re: **Geotechnical Recommendations - Grading Plan Review**
Proposed Residential Development – Block 324 - CRT Lands
723 Putney Crescent - Ottawa

file: PG2236-MEMO.09

- General Plan of Services – CRT – Block 324 – Project No. 126715 – Sheets No. 001, 010, 011, 100, 101, 102, 103, 200, 400, 500, 600 and 900 - Issue 2 – Dated July 16, 2021.

SHEET TITLE
GRADING PLAN

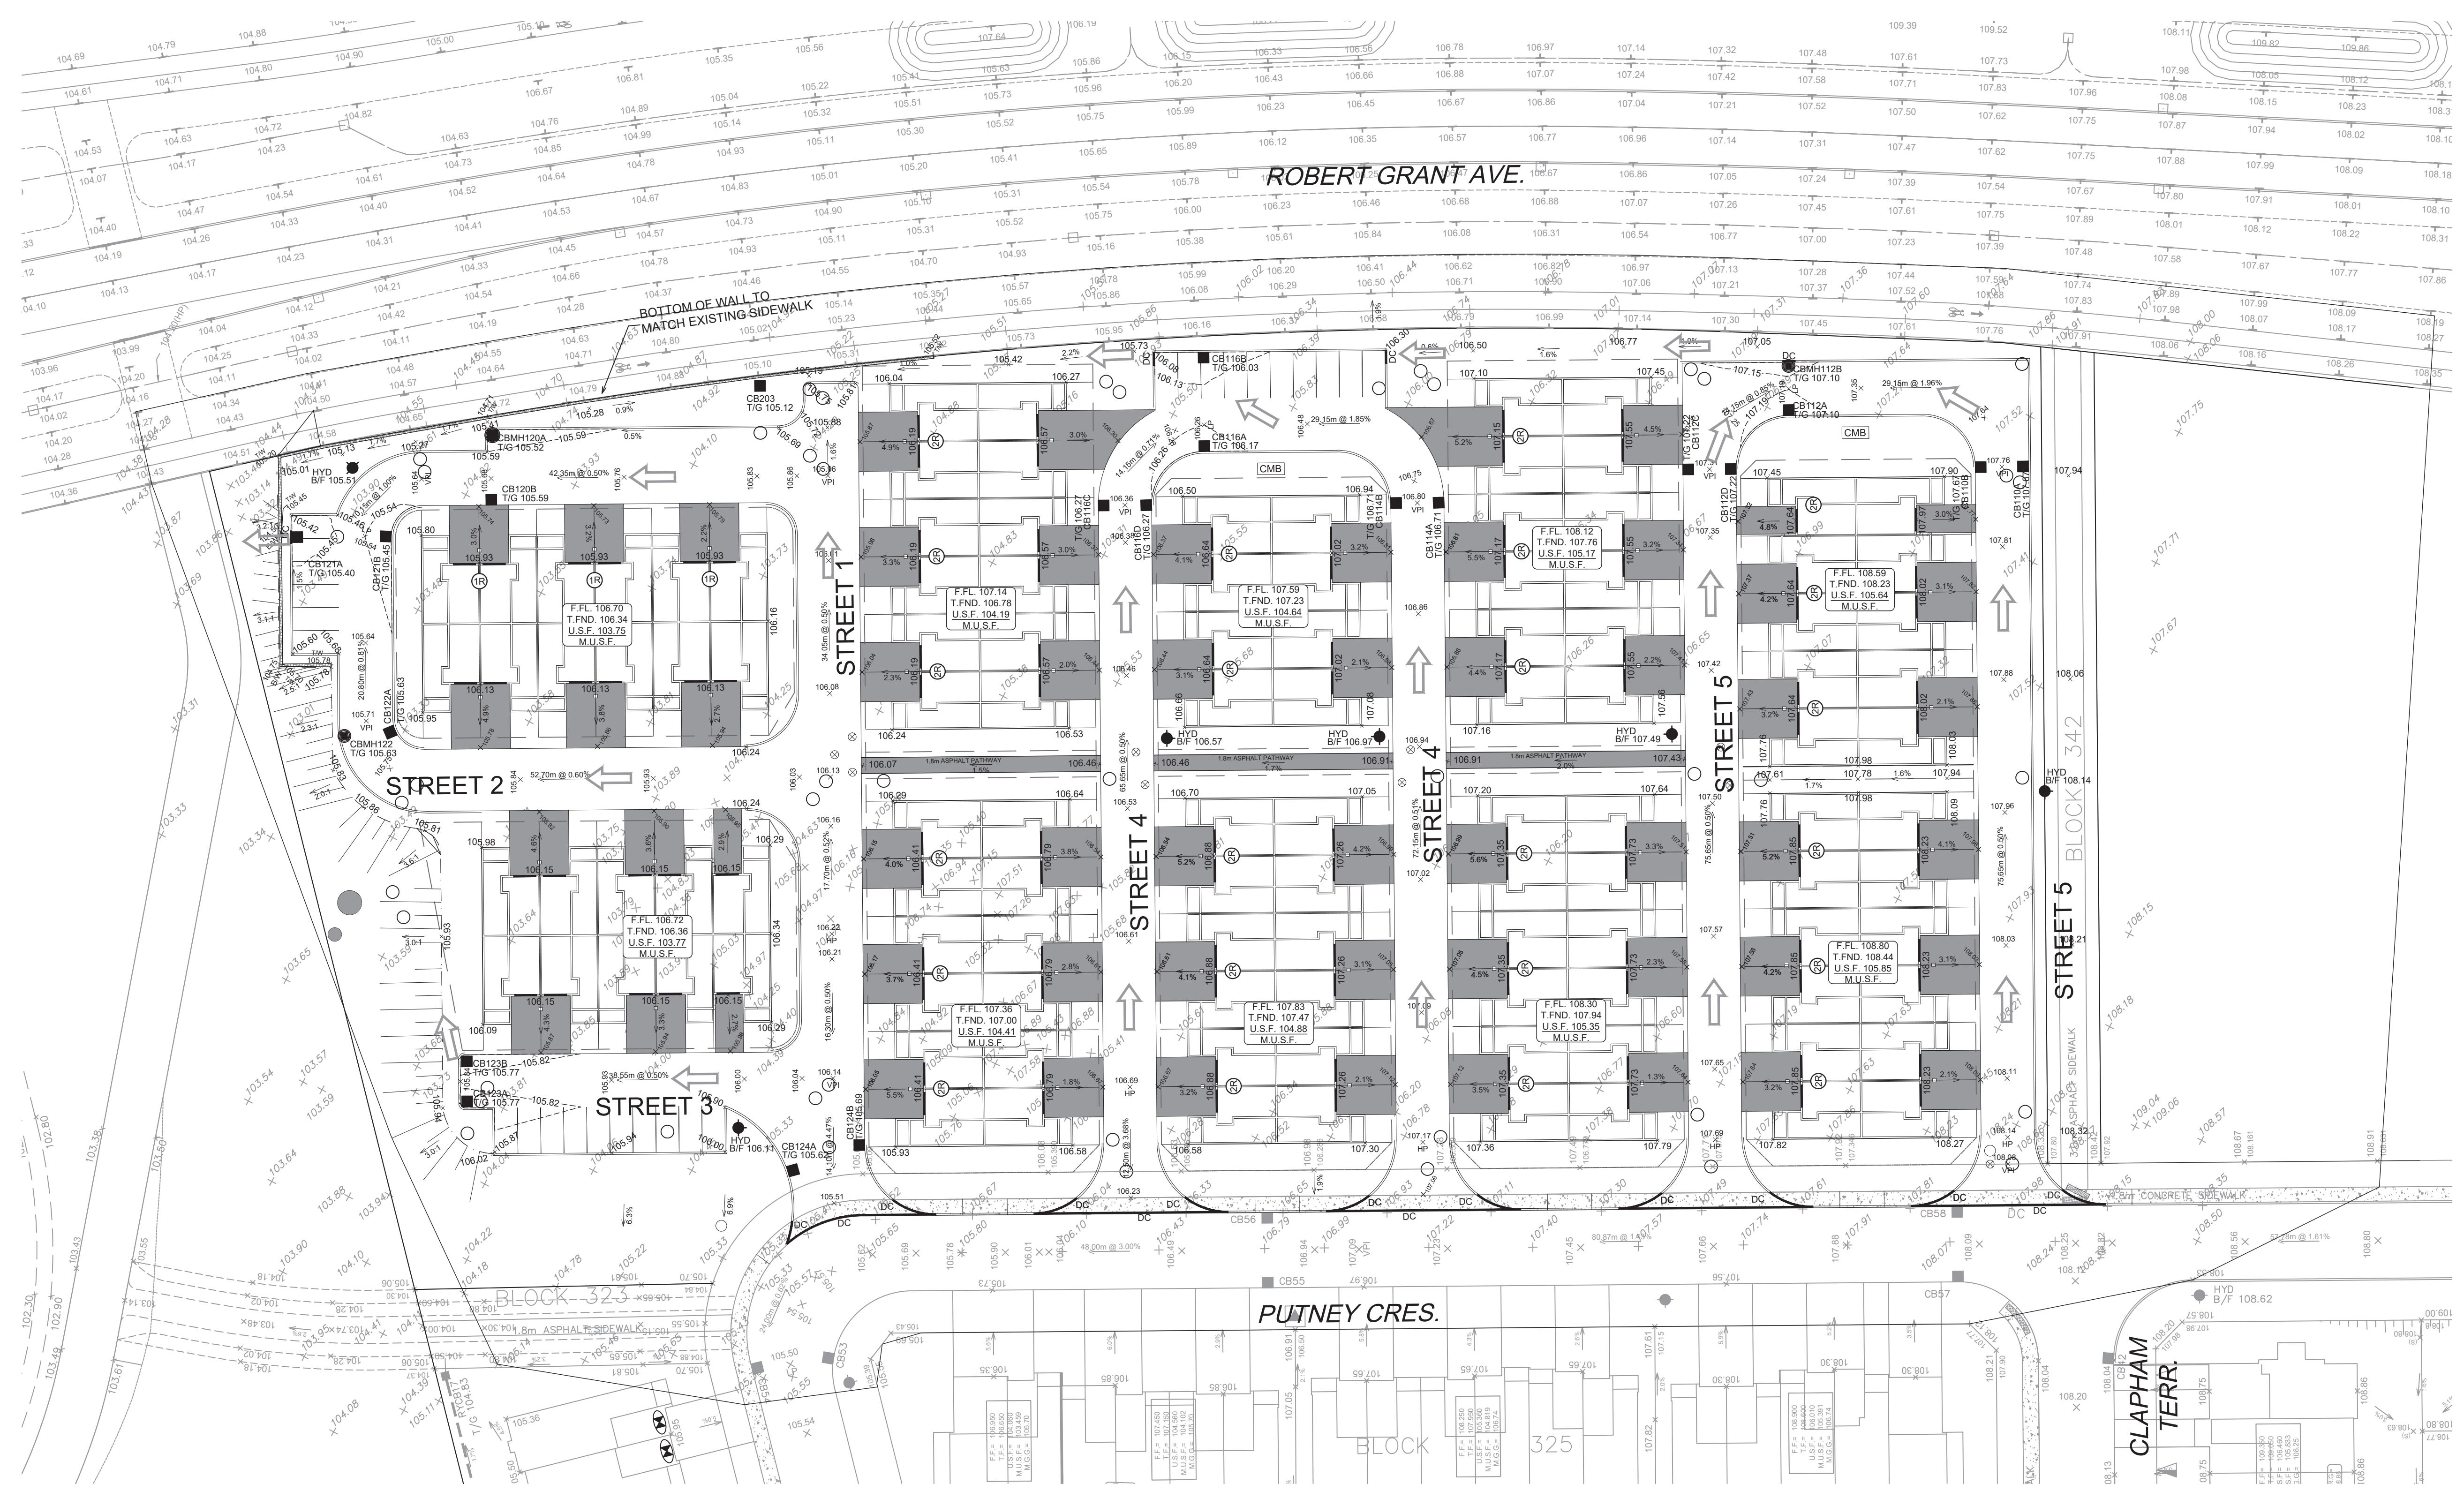
Due to the lack of a sensitive clay layer, the aforementioned site is not subject to a permissible grade raise restriction. Therefore, the proposed residential lot grading is considered acceptable, from a geotechnical perspective, and no lightweight fill or other considerations to accommodate the proposed grades are required.
